April 3, 2013

**Re: Albuquerque Sporting Center
Tract A-1, Albuquerque West Unit 2
Engineer's Stamp dated 3-21-13 (C13/D029)**

Albuquerque
Based upon the information provided in your submittal received 4-01-13, the above referenced report can not be approved for Site Plan for Building Permit based on the following comments:

ENGINEER'S SEAL	PRIMROSE SCHOOL OF NW ALBUQUERQUE	DRAWN BY pm
	GRADING PLAN	DATE 3-20-18
		DRAWING
		SHEET # 4
		JOB # 2017092

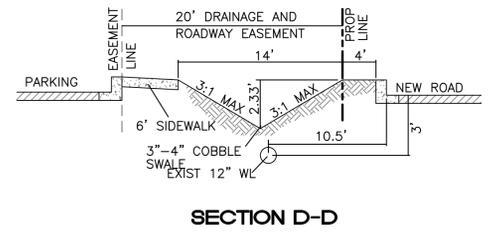
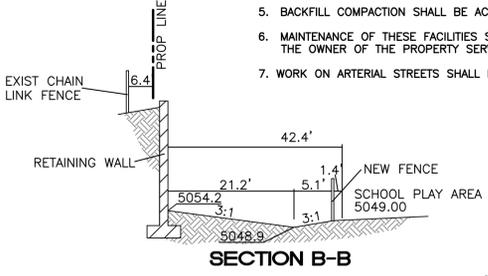
- Provide more detail grades at the northwest corner of the As it was mentioned previously the
- Include the proposed sidewalk (along Paseo Del Norte) on section A-A.
- Provide additional section along Paseo Del Norte further to the west.
- Provide a phasing Grading plan. How will the runoff reach the existing concrete runoff? Will the entire site be graded with Phase 1? Will there be desilting pond at the discharge point of the runoff into the City right-of-way.
